Enclosure (1)

**Parcel Maps**

Encl 1 Parcel Maps_v1 comments.pdf Markup Summary 10-31-2022

EXHIBIT A PROPERTY MAP

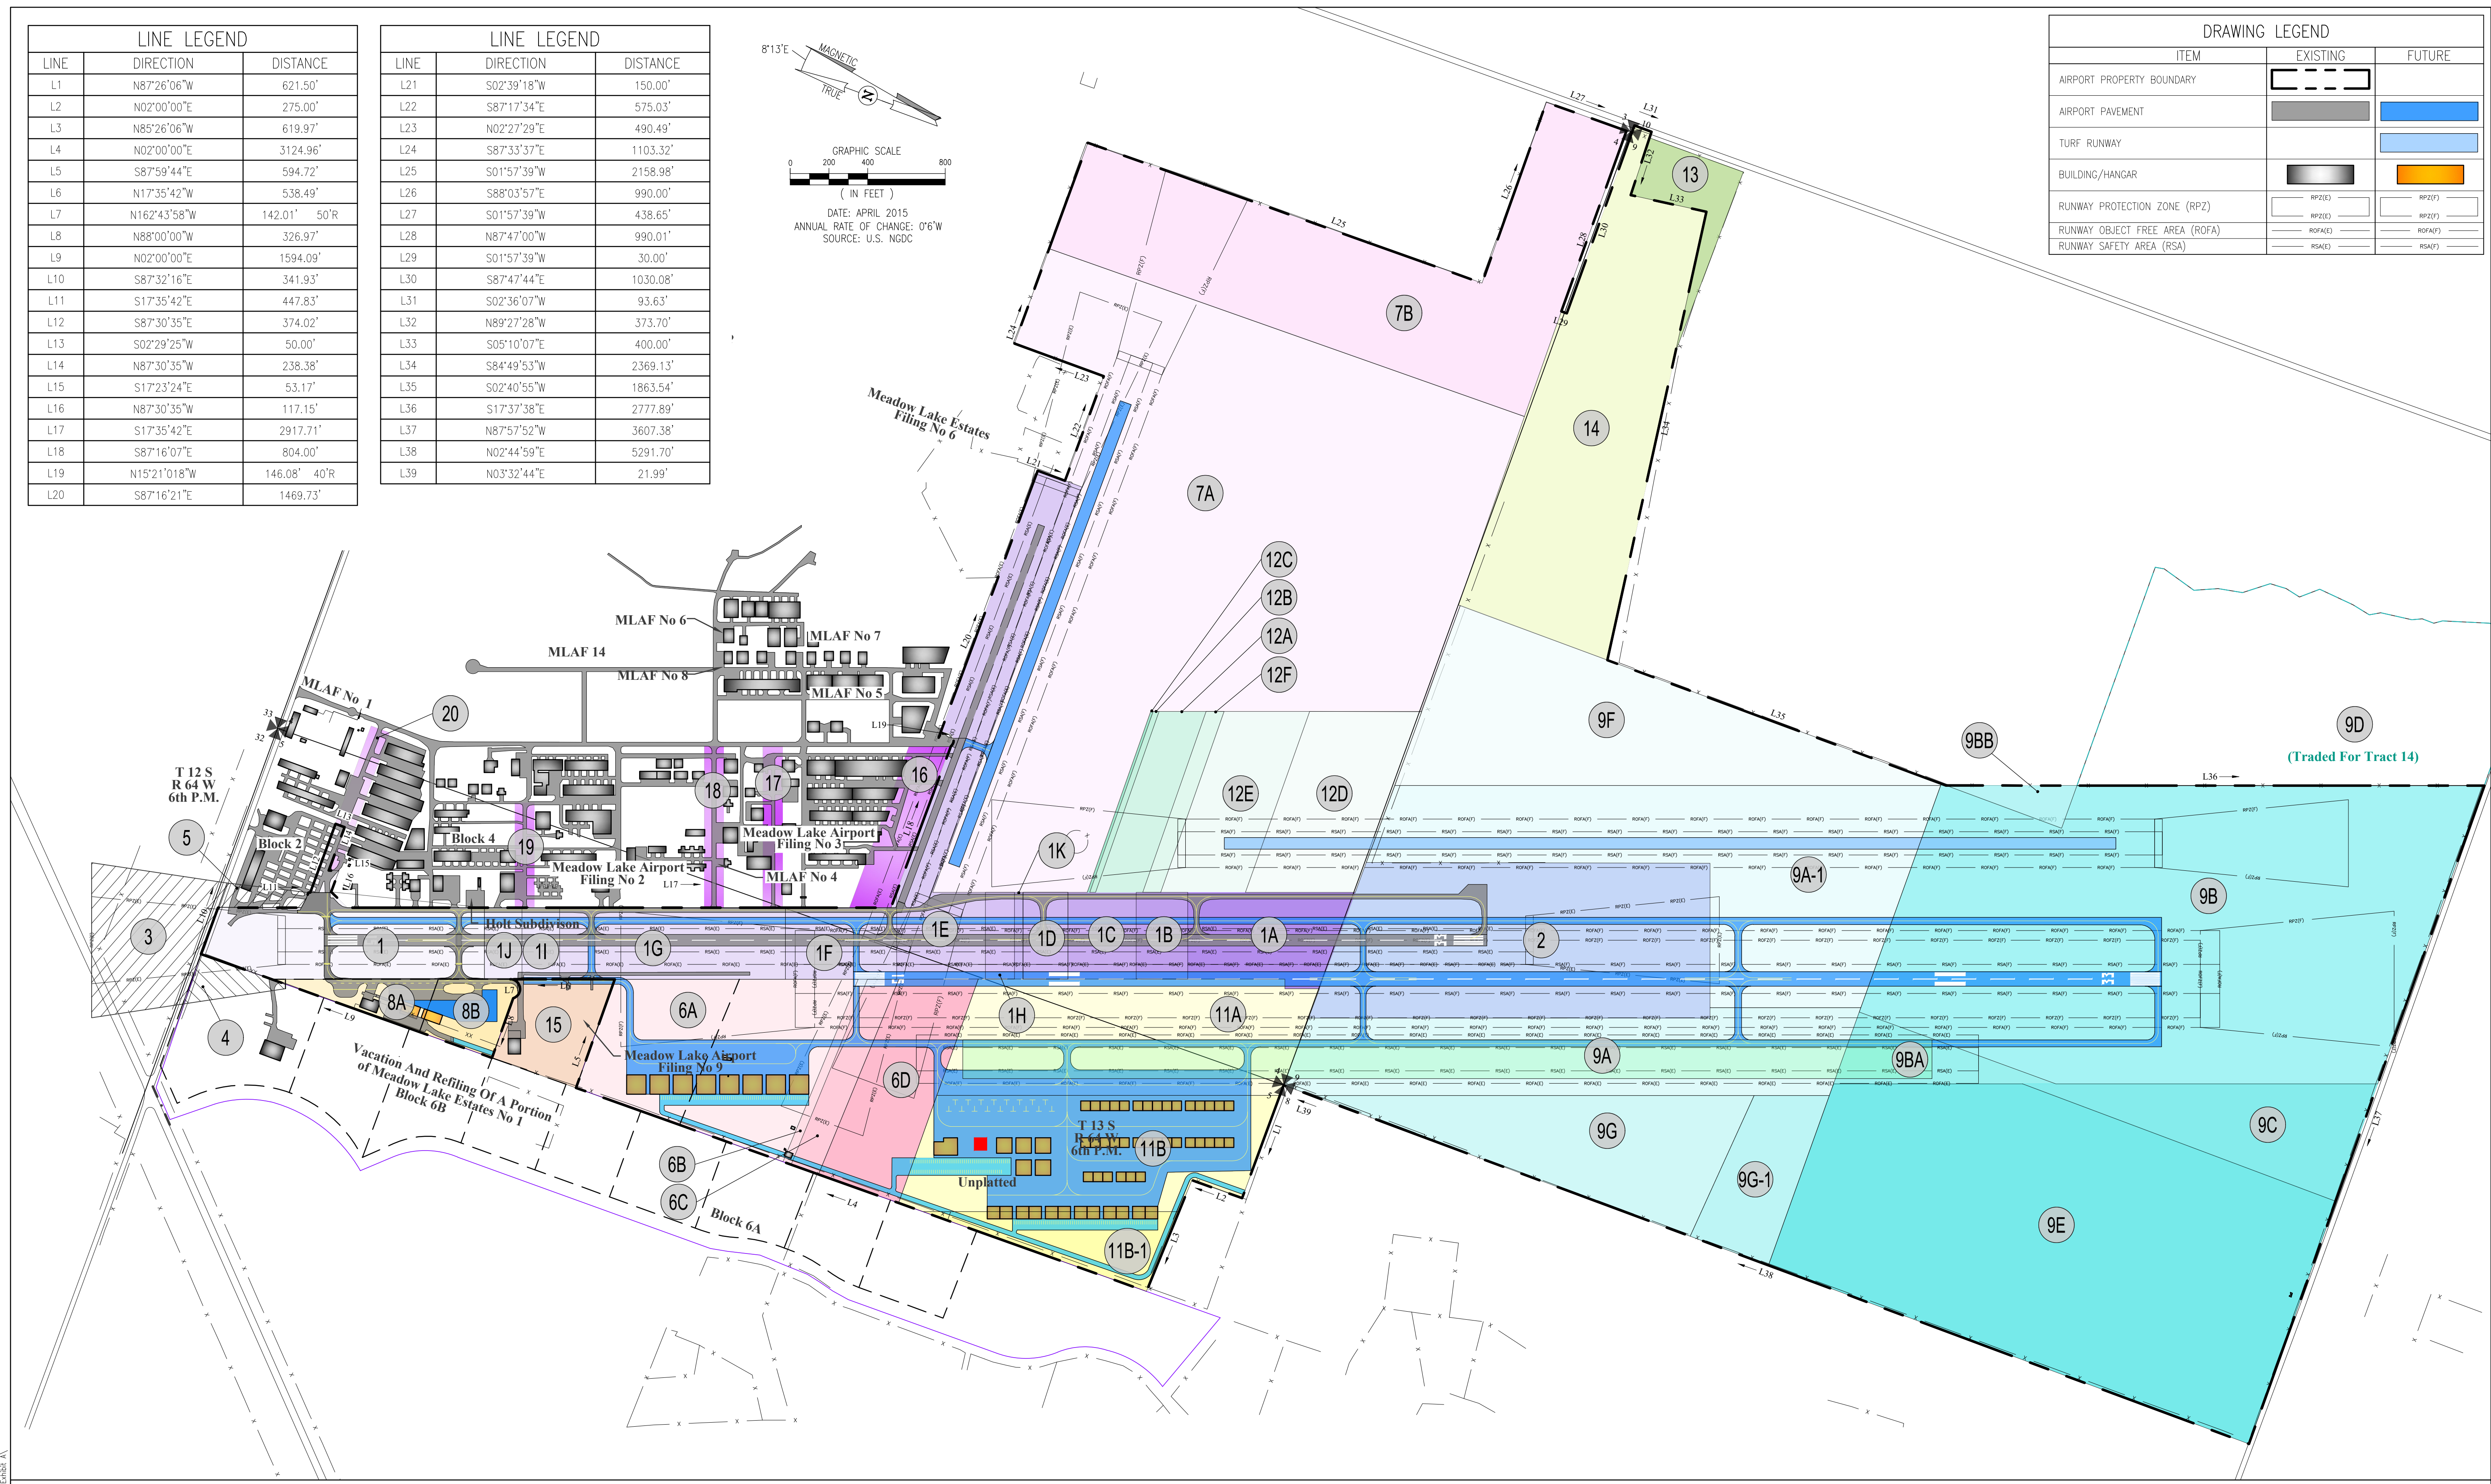
There shall be a map included identifying the parcels owned by others that are within the Meadowlake Airport. They are included in this 1041 site selection and expansion.
